Environmental Health Consultation Response

To	Hebe Smith
Date	01-11-2025
Planning Ref	BR/179/25/DOC
Site Description	1 Highfield Road Bognor Regis West Sussex PO22 8BQ
Date of Application	2025-10-17 00:00:00
Category	Discharge Of Condition
Recommendation	No Objection No Objection — with conditions Objection Holding Objection

MECHANICAL VENTILATION
HEAT RECOVERY.
GROUND FLOOR

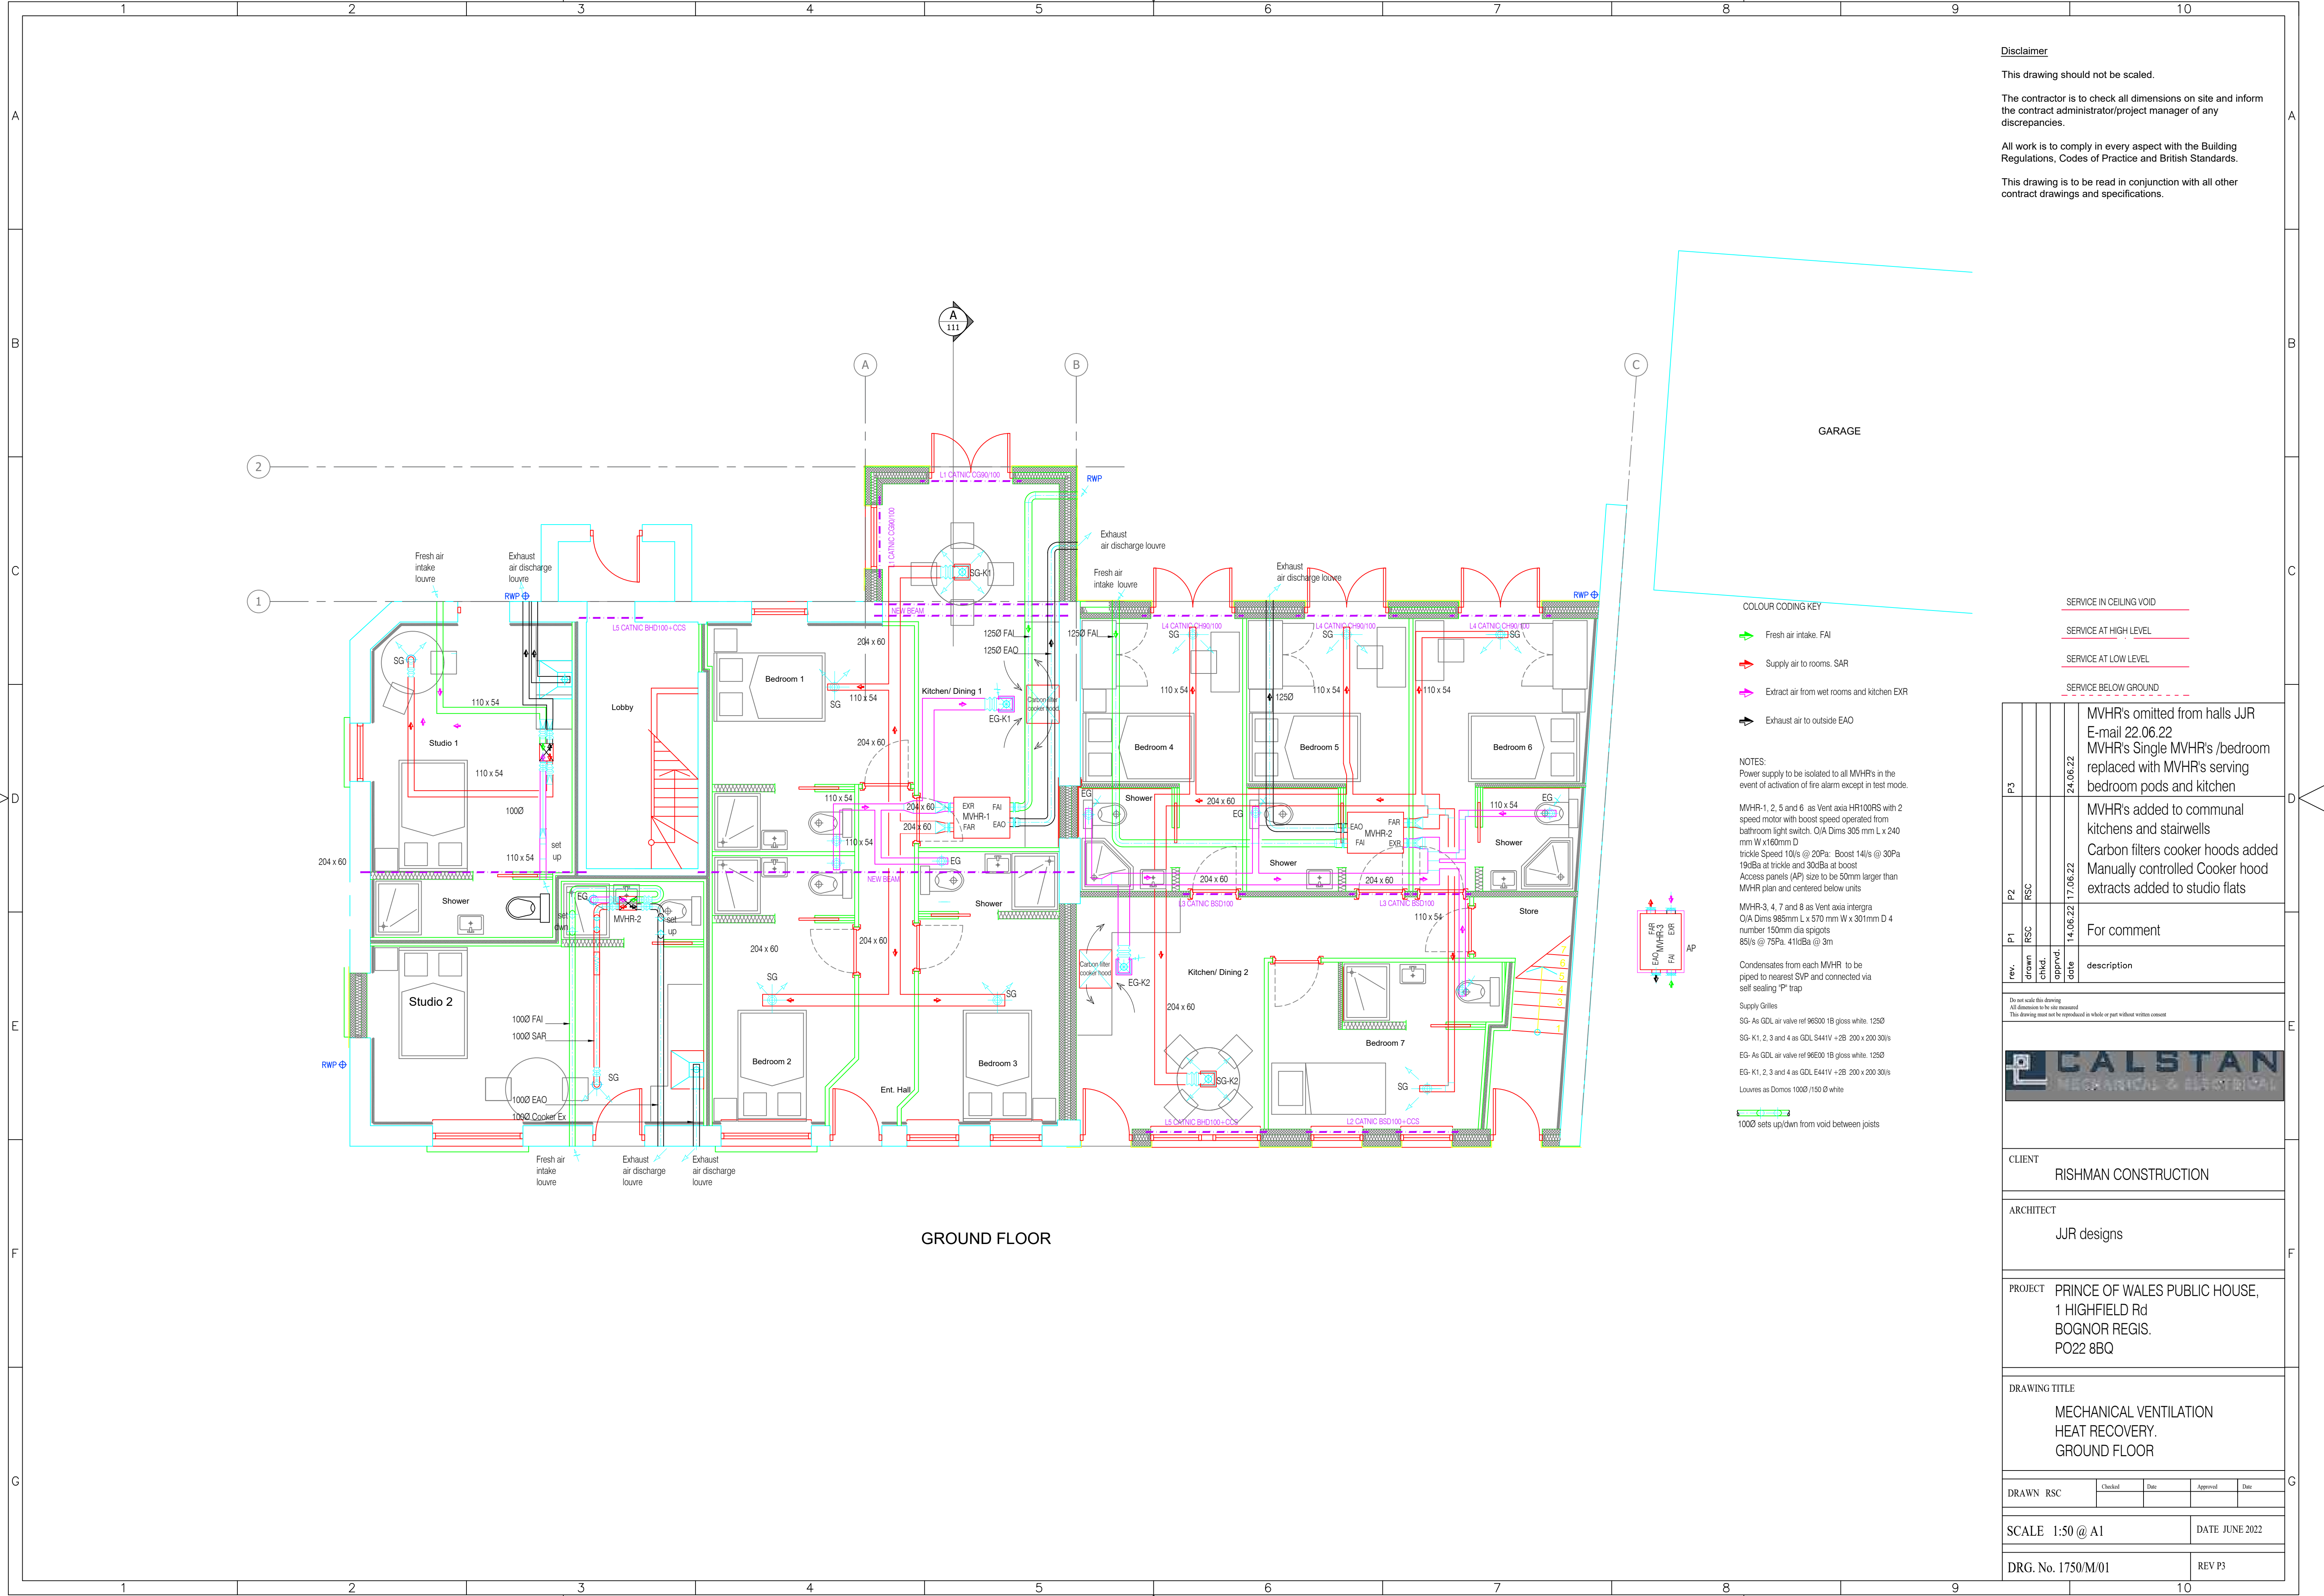
One area that does need further clarification is the ventilation arrangements. Condition 4 also states that "The scheme should take into account the correct number of air changes required for noise affected rooms" this will be to ensure that the windows of the property can remain shut. If a property can't open the windows due to noise, we would expect the ventilation to provide the equivalent of an open window which is deemed to be 4 air changes per hour.
